DRAINAGE MEMO

**LOT 1, SPACE VILLAGE FILING NO. 3
6809 SPACE VILLAGE AVENUE
EL PASO COUNTY, COLORADO**

**May 17, 2018
PCD Project No. SP-17-009
Olsson Project No. 017-1754**

**EXISTING DRAINAGE BASIN MAP**

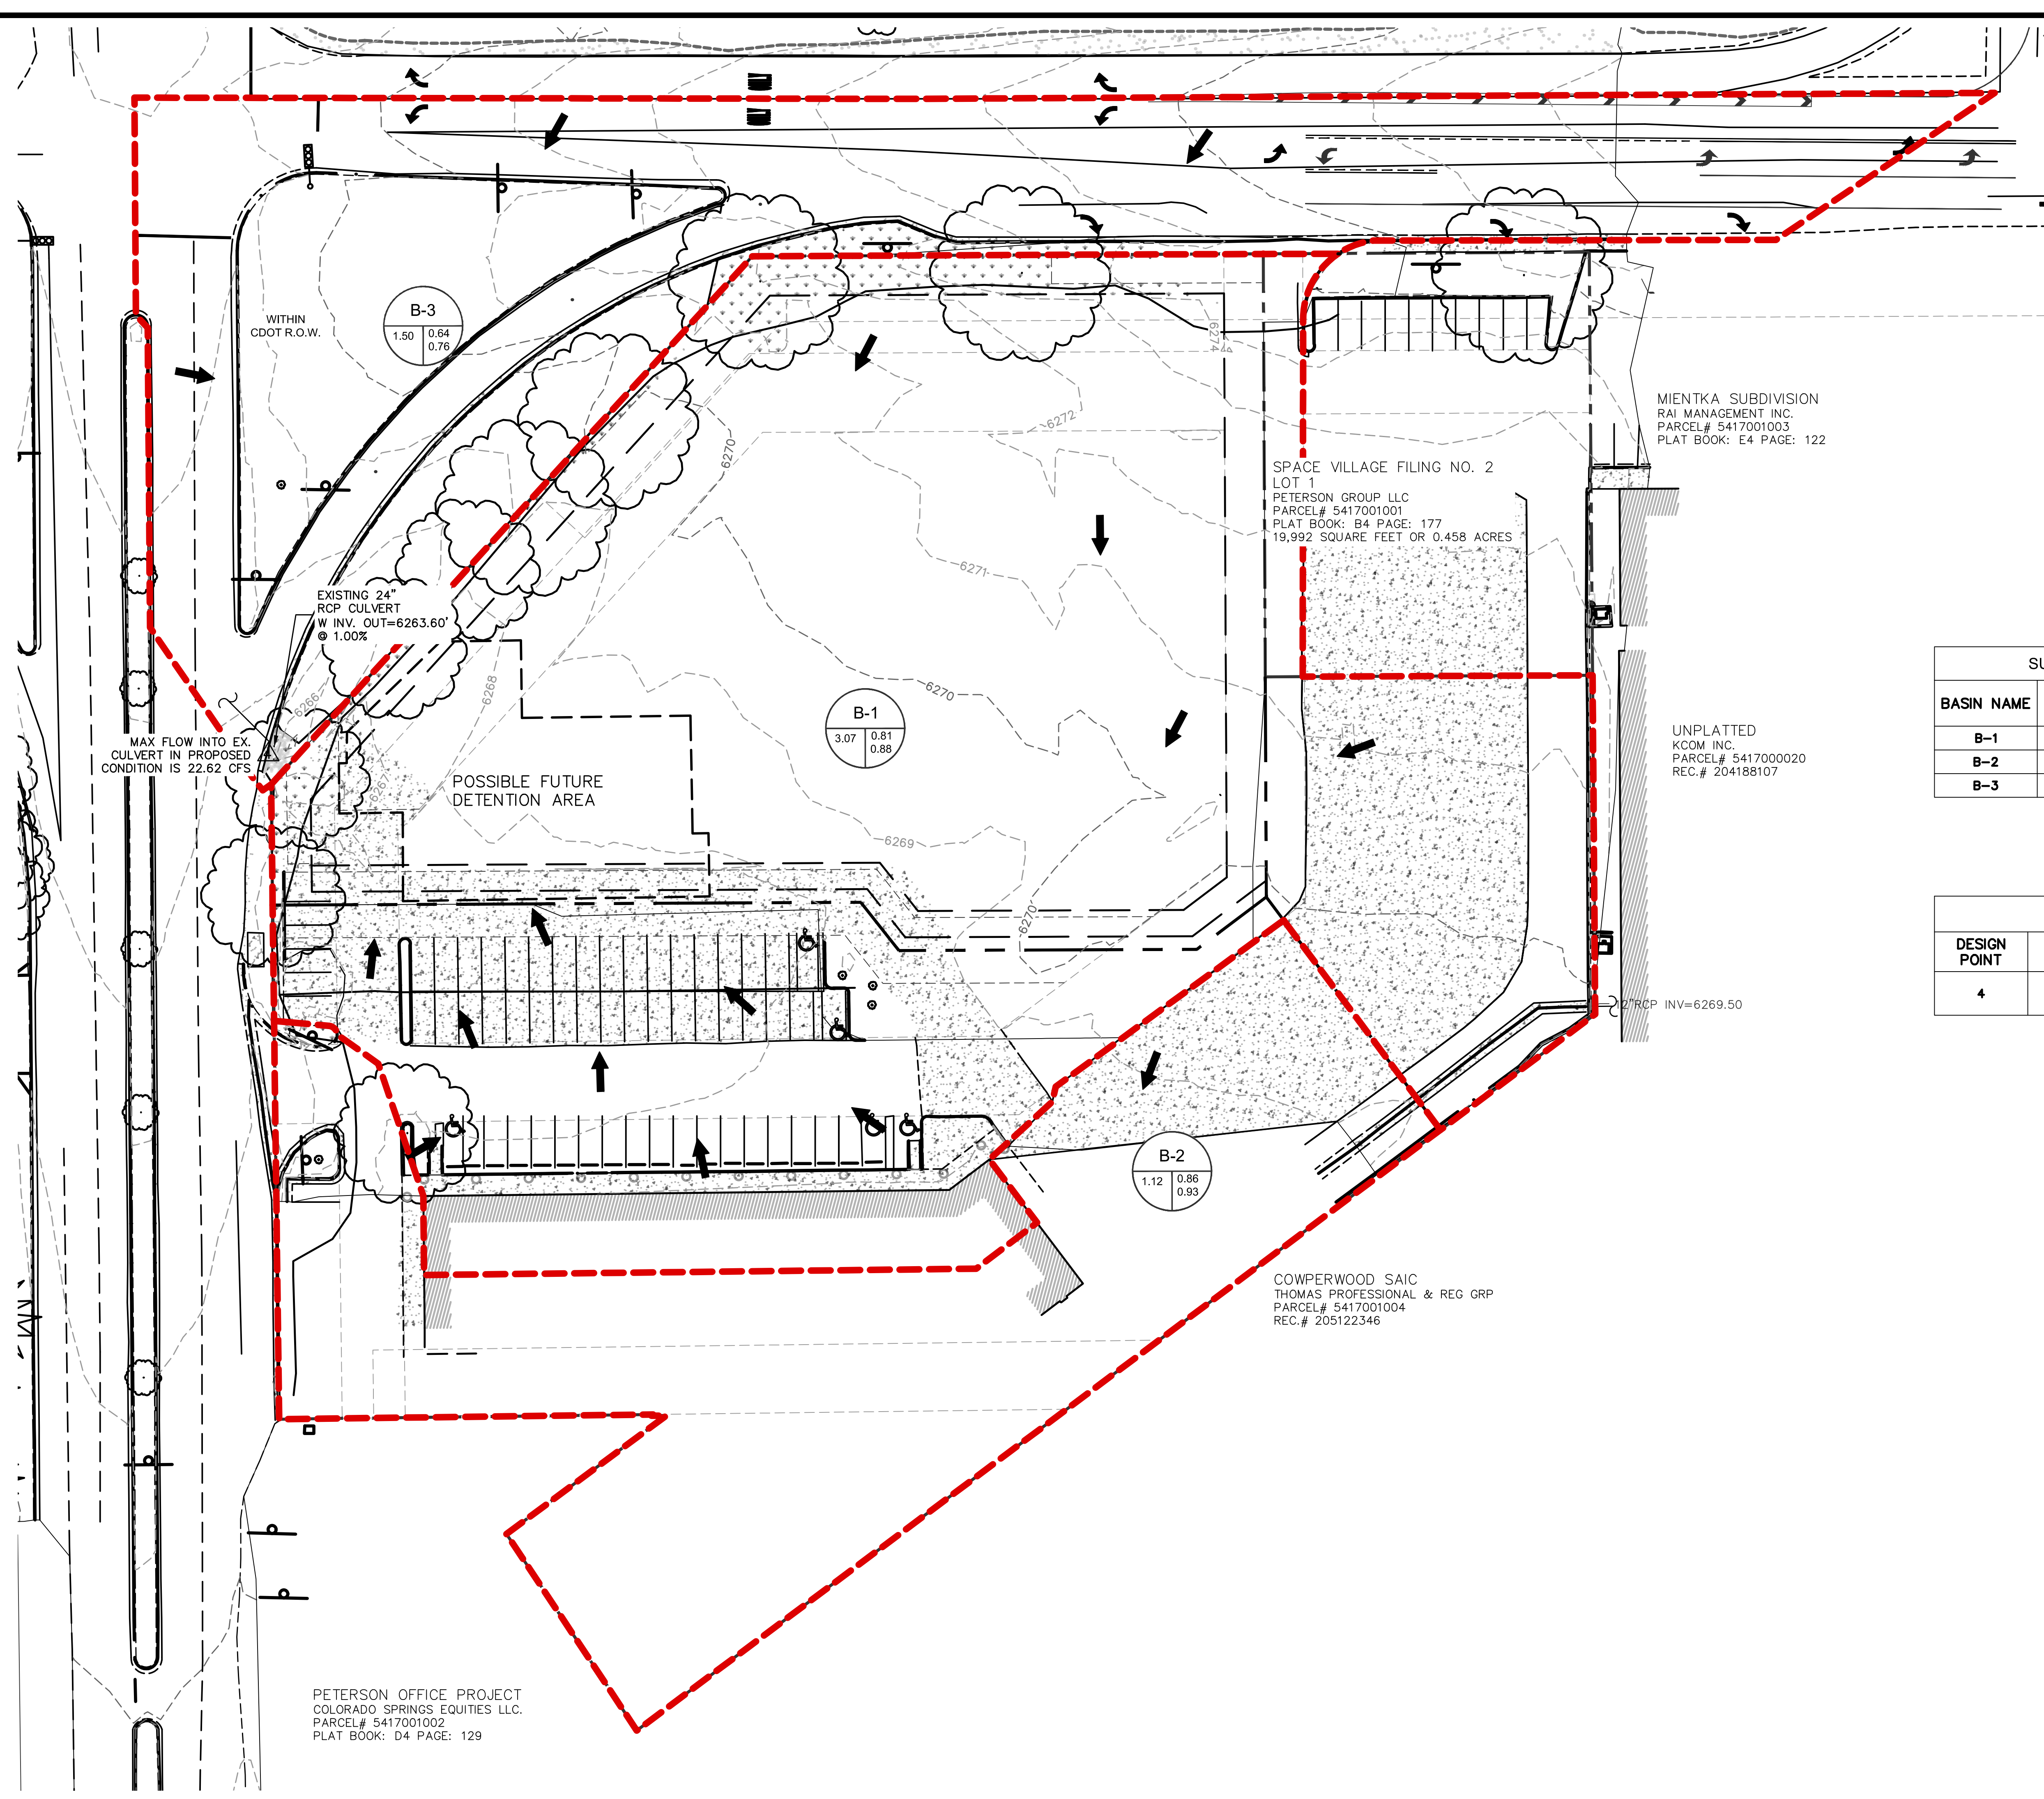
Expand the analysis to include the southern part of the subdivision. Analysis must be for the entire space village Filing 3 property.

Revise DP-4. Contributing Basins at DP 4 is EX-1, EX-2, EX-3
